From: Andrew Hedge [REDACTED]
Sent: 08 February 2016 10:31
To: Richard Temple
Cc: Rachel Bird
Subject: RE: Barnham Court Solar Panel Heights

From: Richard Temple [<mailto:Richard.Temple@arun.gov.uk>]
Sent: 08 February 2016 10:00
To: Andrew Hedger
Subject: RE: Barnham Court Solar Panel Heights

The development hereby approved shall only be carried out in accordance with the approved Flood Risk Assessment (FRA) Ref: ICBR0039_FRA with drawings 2768_04 Rev A and 2768_03 D and the following mitigation measures detailed within:

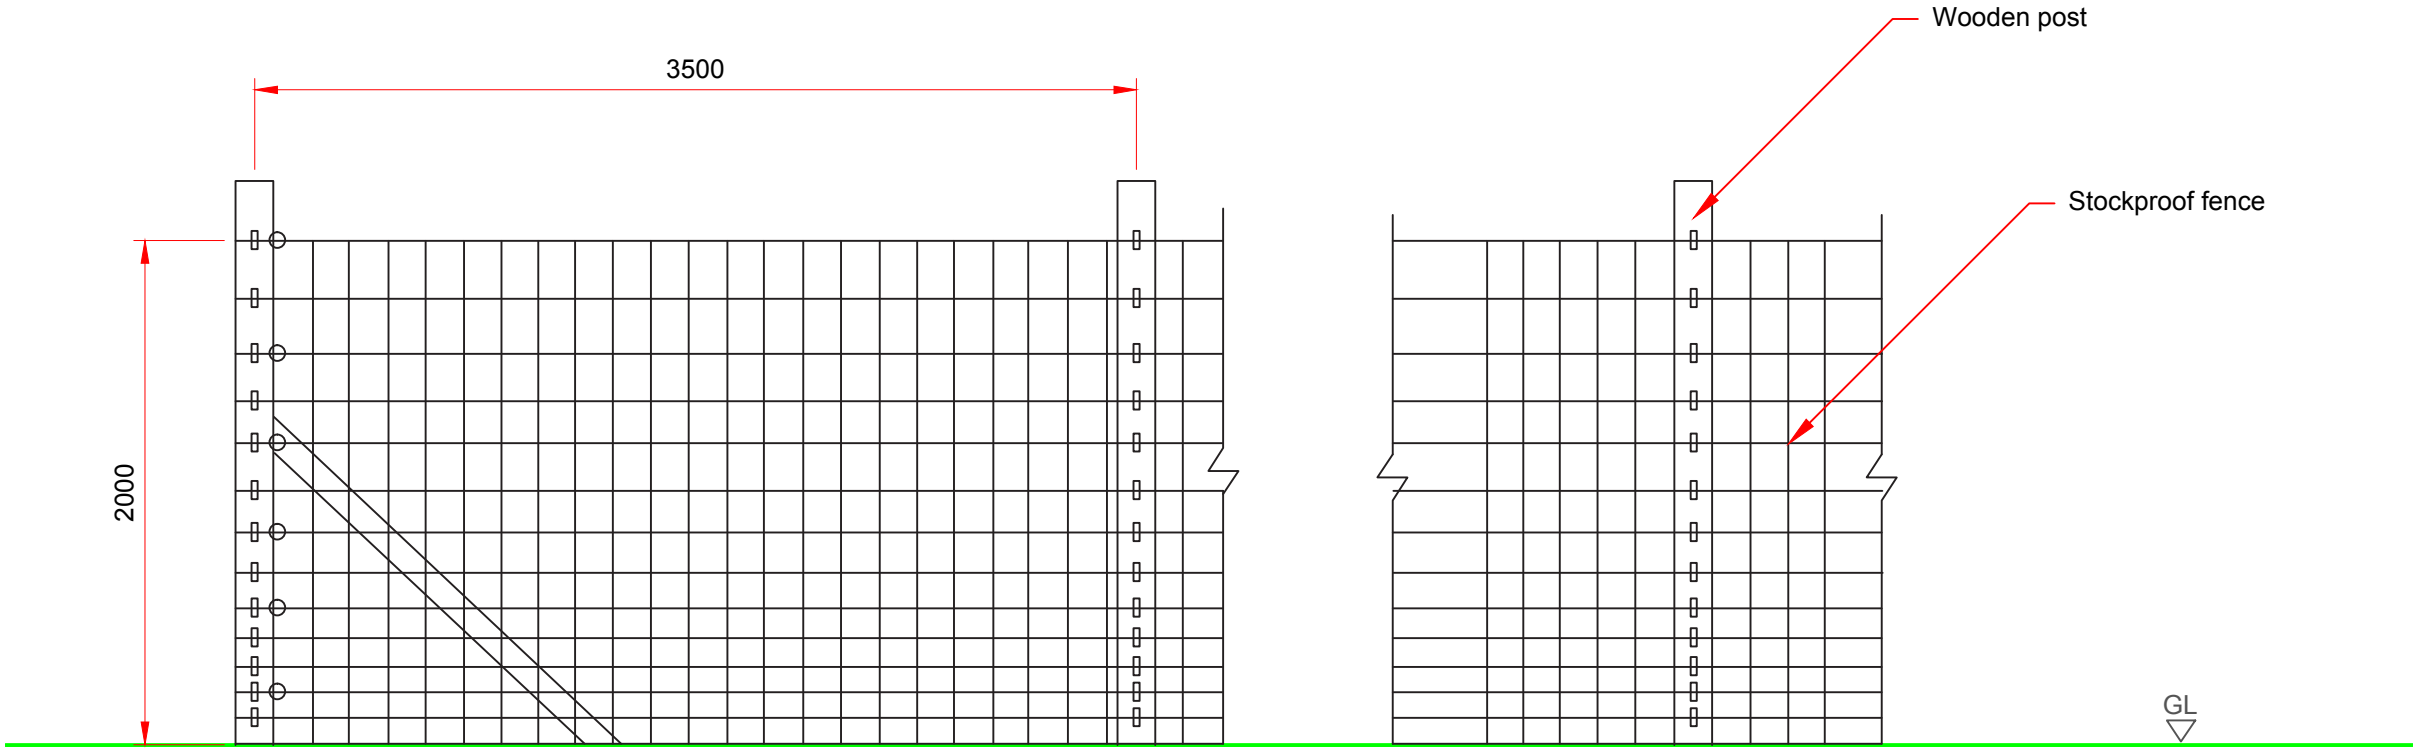
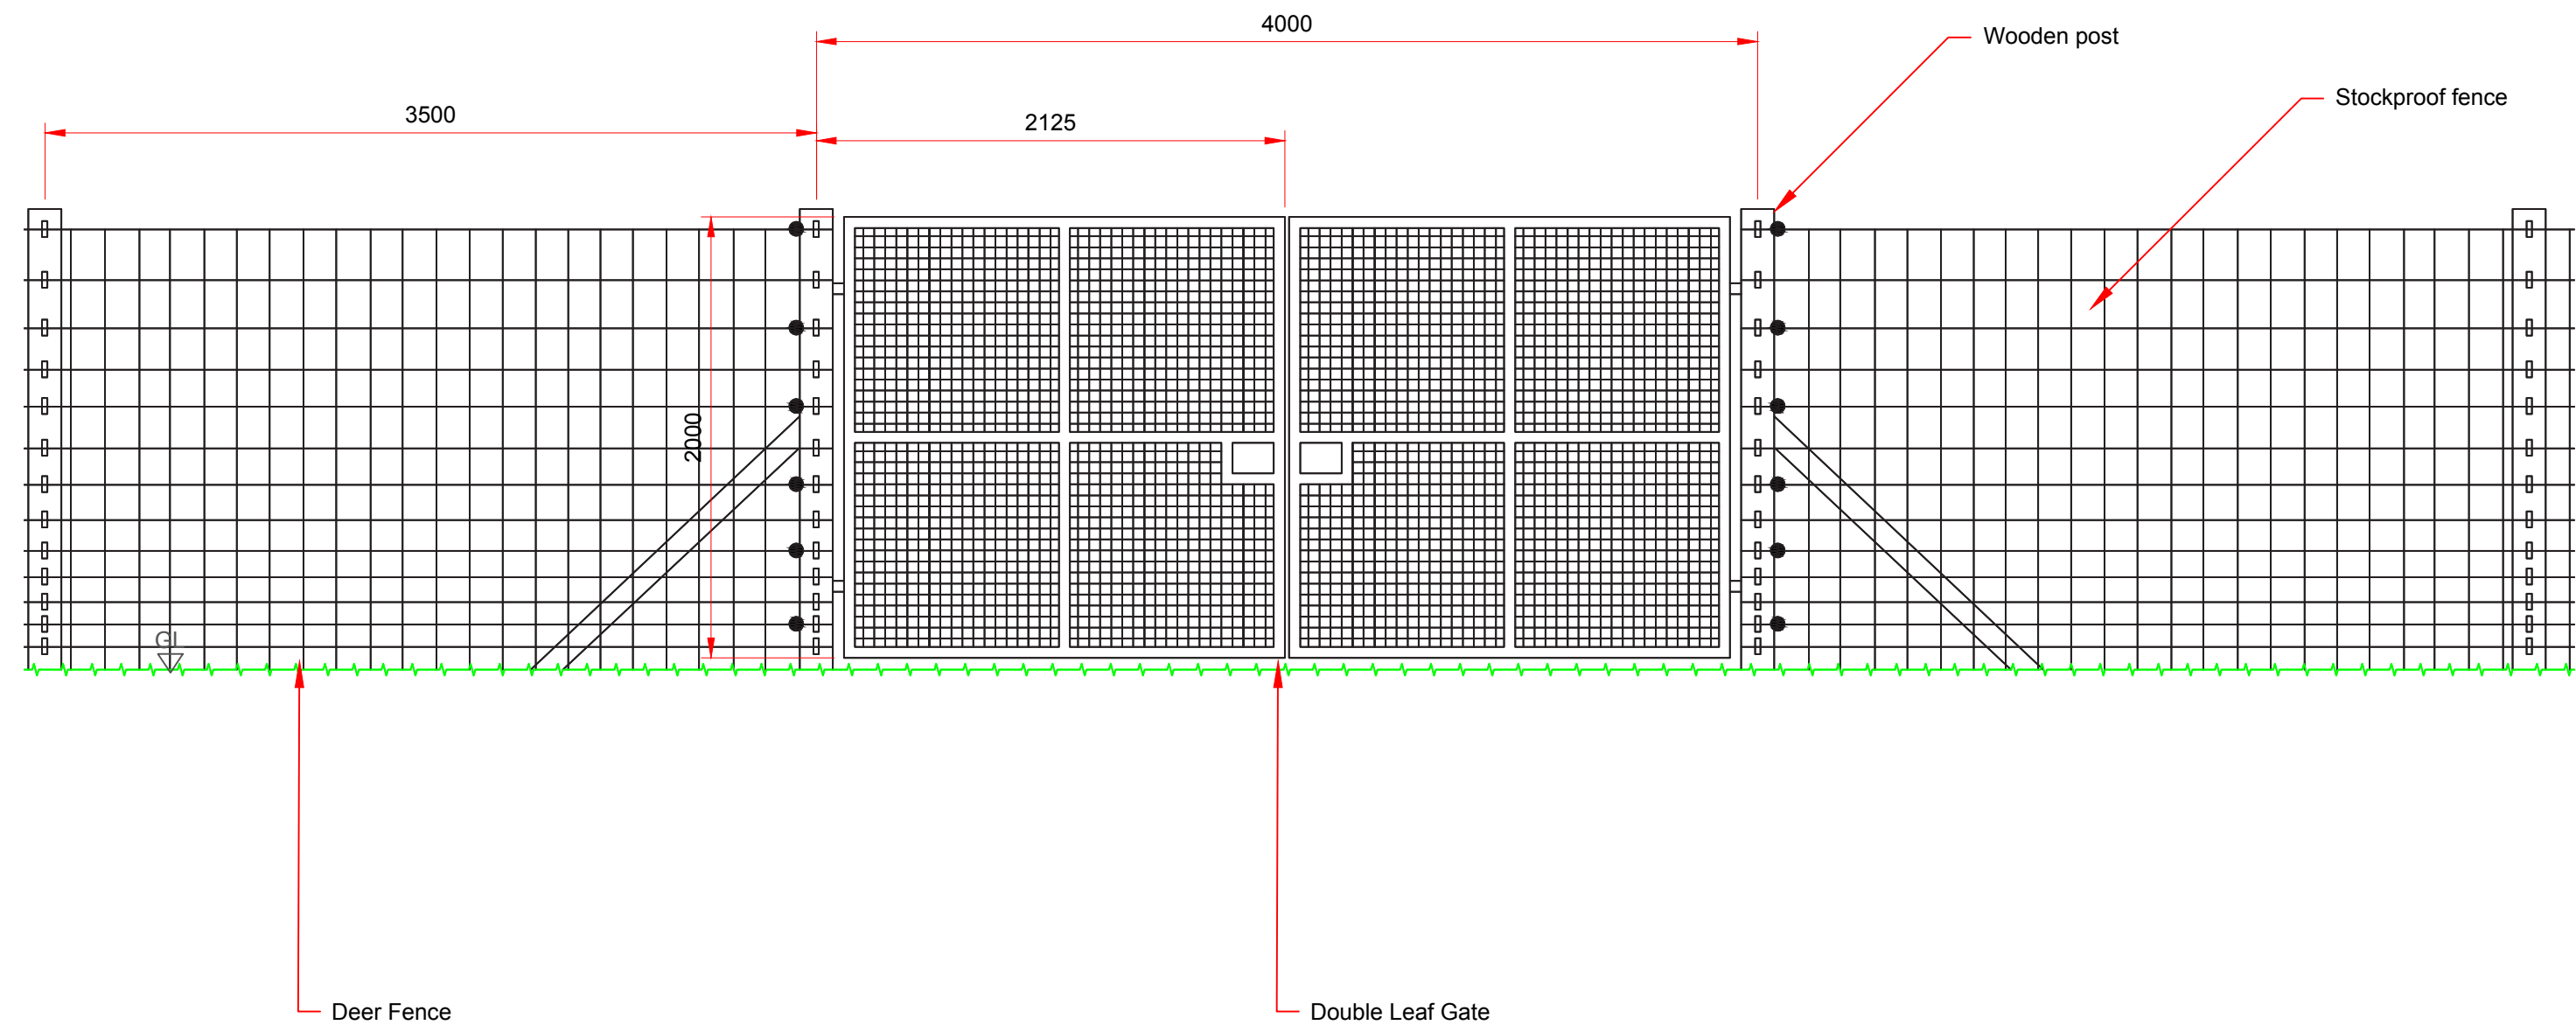
-drawing 2768_04 Rev A, the lower edge of the panels should be no lower than 1.3m above existing ground level (2.3m Above Ordnance Datum (AOD). This is in line with the flood level of the 1 in 100 year plus climate change (1% Annual Exceedance Probability plus 20% allowance for climate change).

Further to our telephone conversation on Tuesday, the applicant has confirmed that it is possible to allow the trailing edge to be brought up to 1.3m with the top height remaining at 2.5m. This involves a change in the number of panels per array and a slight change in the angle of the panels.

'Instead of 4 (@300) in landscape we will have to do 3 in landscape at 23.50 degrees, with 1.3m at the trailing edge and 2.5m at the leading edge.'
